### INTAKE SCREENING COMMENTS RESPONSE

Permit Number **2208-260**

Project Address 8455 SE 83<sup>RD</sup> ST.  
Mercer Island, WA 98040

Subject **Response to Building Permit Intake Screening Comments**

2 HARD SURFACE CALCULATION
 T = 20'-0" 210A-SITE DIAGRAMS.dwg

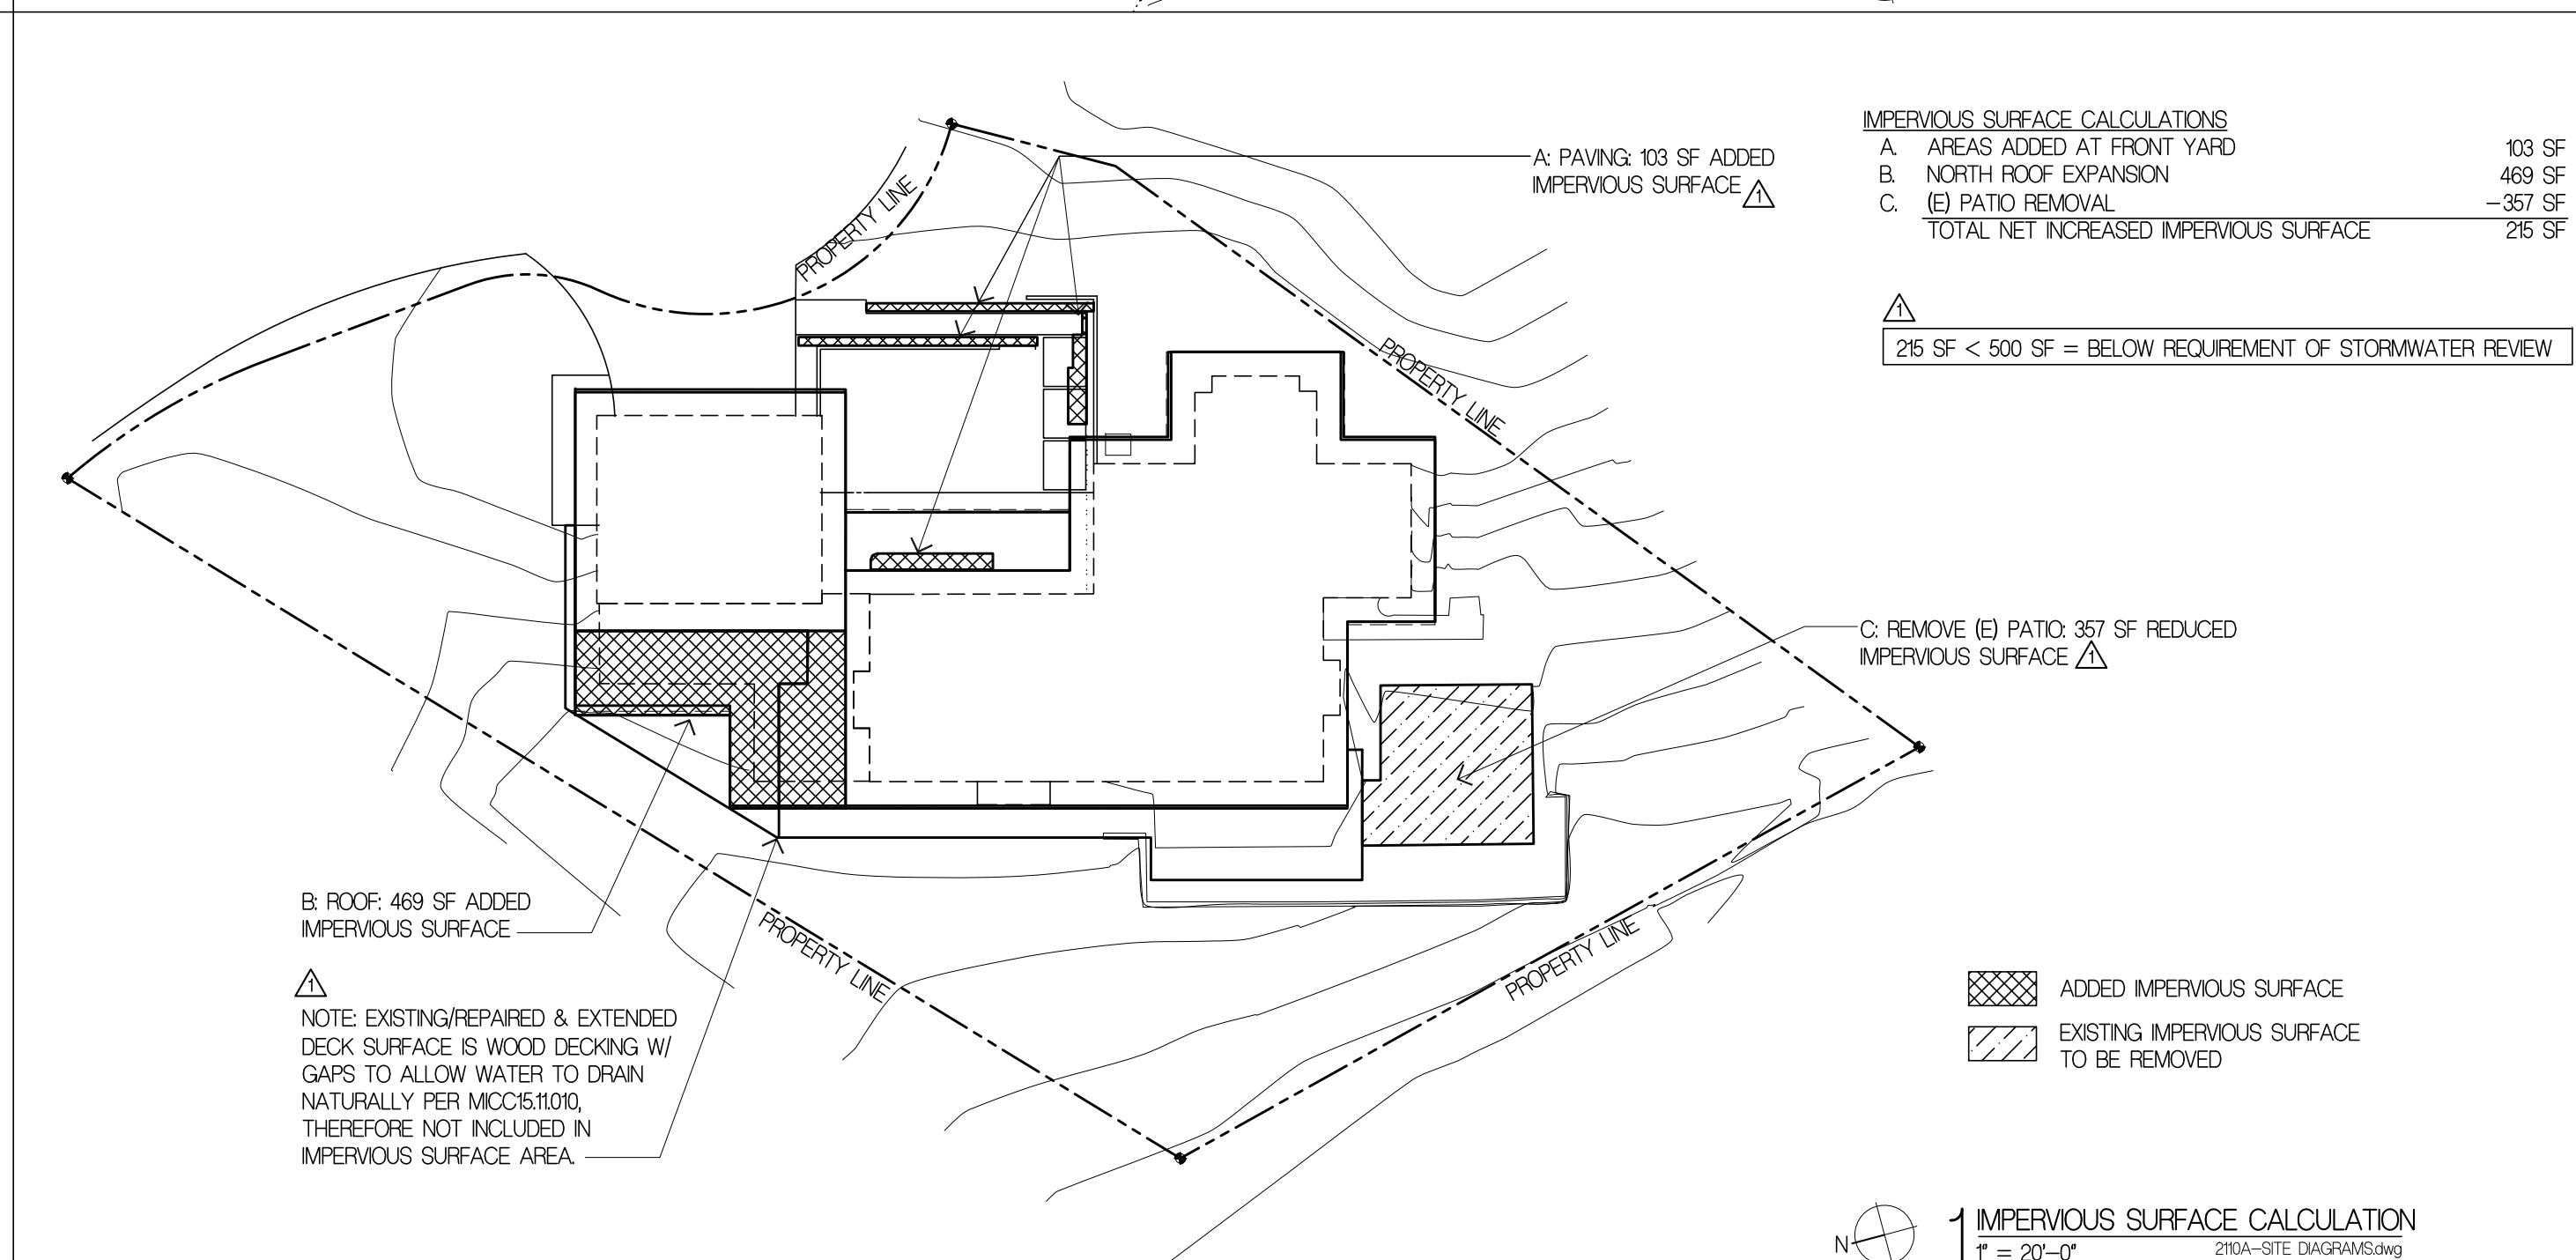
1. **Demonstrate that New plus Replaced Hard Surface is less than 2,000 sf:**  
Response: Please refer to the revised sheets – Site Diagram 2/TS-4, Demolition Floor Plans A1.0a & A1.0b, and A3.3, to clarify the scope of work showing that the proposed work involved is less than 2,000 sf of New plus Replaced Hard Surface.
